Our Ref: 23/1251/TTCA
Your Ref: Washington

South Cambridgeshire District Council
Application for Works to Trees in a Conservation Area

Proposal: T1 Willow in neighbouring property on ditch bank. Remove lower limb leaning at an angle and reduce remaining overhanging limbs above that limb by up to 3ms to minimise likelihood of branch failure.

Site address: Orchard House Field Road Kingston Cambridgeshire

Ref. WASHINGTON
Tree Location Plan

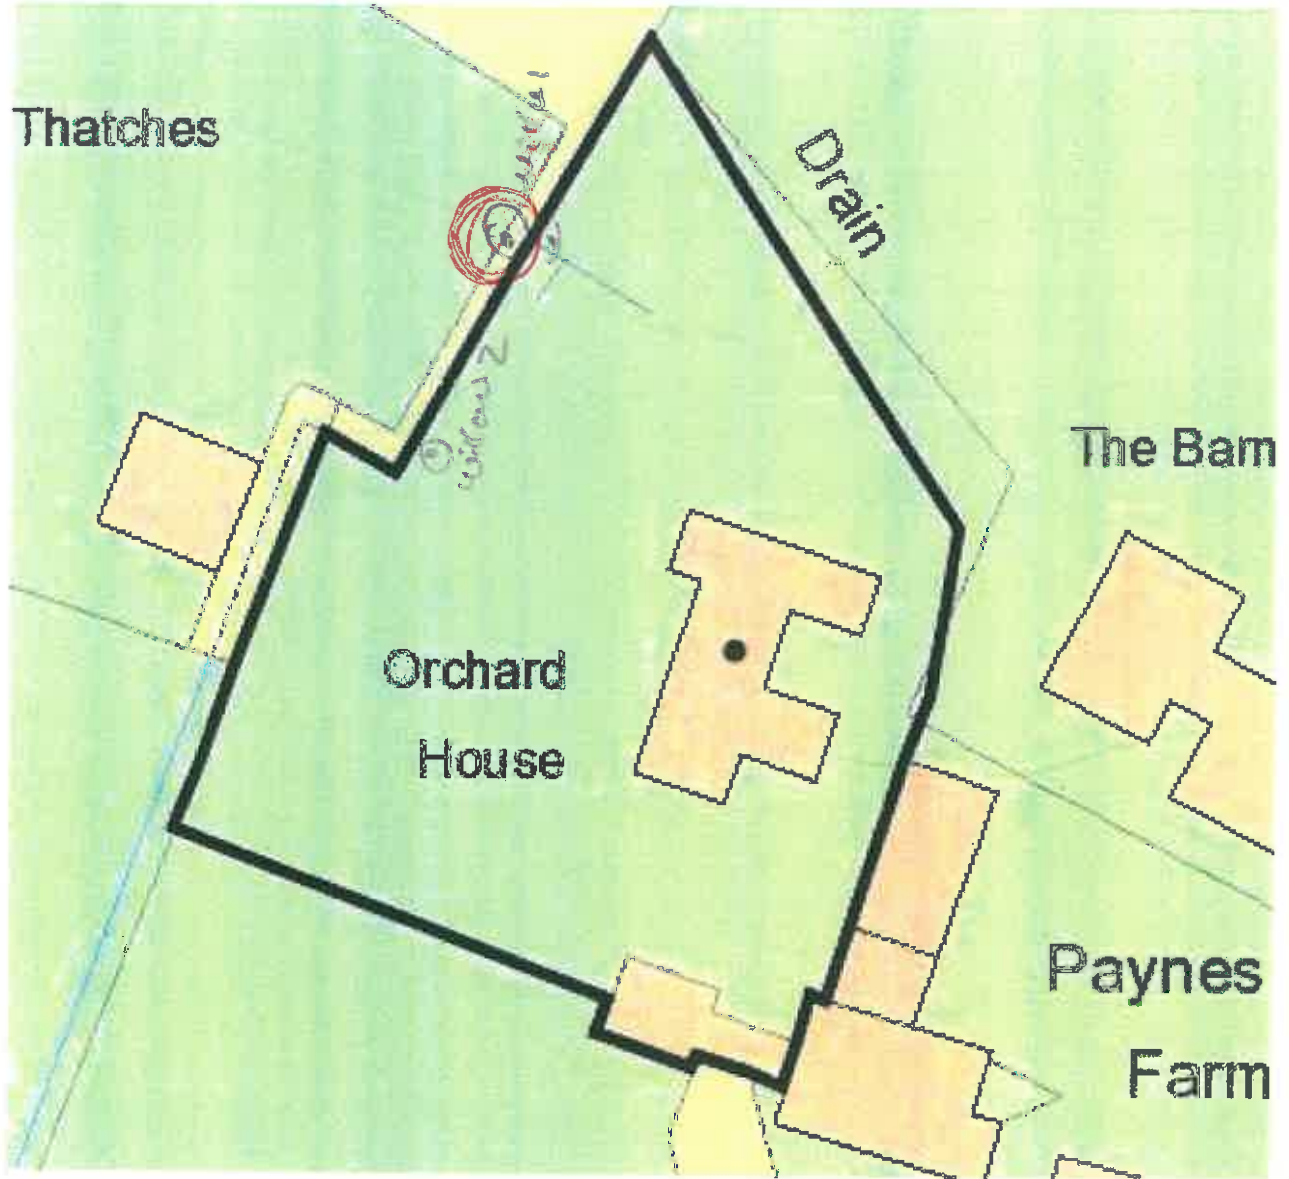
0. The tree location plan does not match a map of the location. The location address on the application should be the location of where the tree stands .
